United Utilities Water PLC  
Developer Services & Planning  
Thirlmere House  
Lingley Mere Business Park  
Lingley Green Avenue  
Great Sankey  
Warrington WA5 3LP

**Your ref:** 3/2012/0913  
**Our ref:** DC/12/4348  
**Date:** 29-NOV-12

**Location: Land Waddington Road, Clitheroe**  
**Proposal: Outline Application for a residential development and a creche**

**OS Sheet No: SD7342SE**

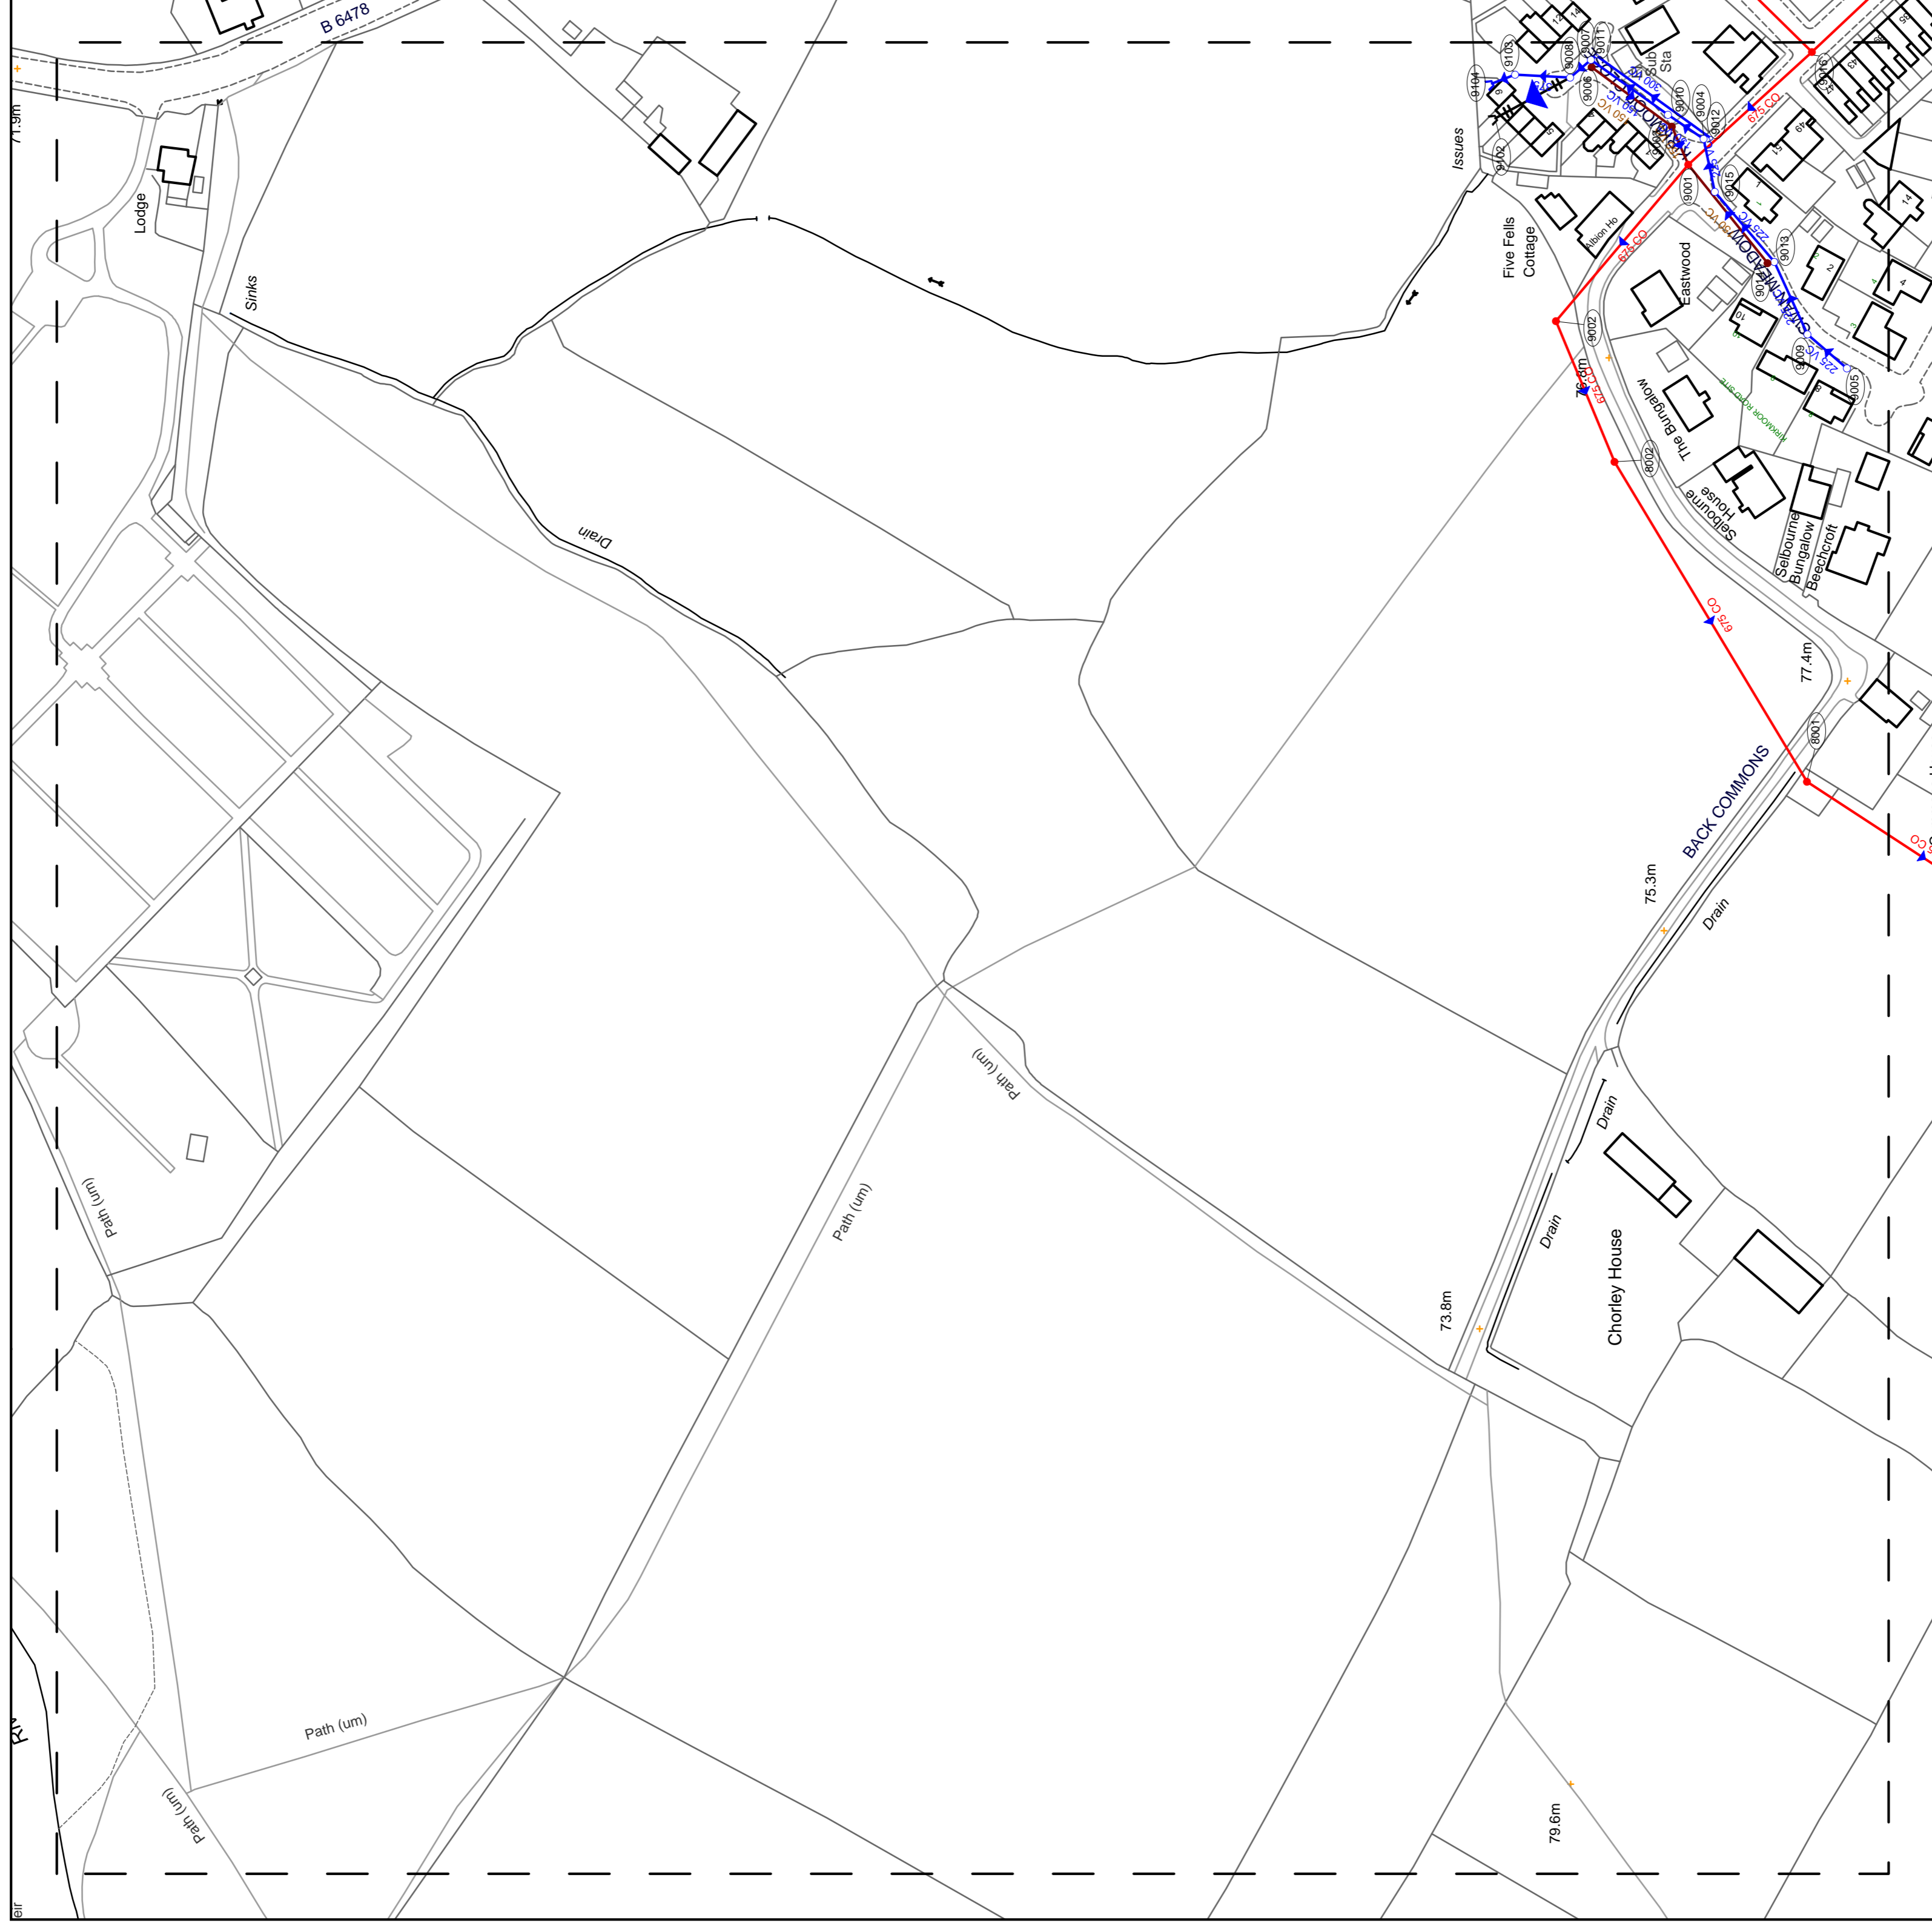
A significant public sewer crosses this site and we will not permit building over it. We will require an access strip width of 10 metres, 5 metres either side of the centre line of the sewer which is in accordance with the minimum distances specified in the current issue of "Sewers for Adoption", for maintenance or replacement.

- Prior to the commencement of any phase of development, details of the foul drainage scheme for that phase including any necessary infrastructure shall be submitted to and approved in writing by the local planning authority. No housing shall be occupied for that phase until the approved foul drainage scheme for that phase has been completed in accordance with the approved details. Unless otherwise agreed in writing, the approved foul drainage scheme shall only connect to the foul sewer network between manhole reference 8001 on the existing 675mm combined sewer & manhole reference 9002 on the existing 675mm combined sewer, both are which located at grid reference 373861, 442060.
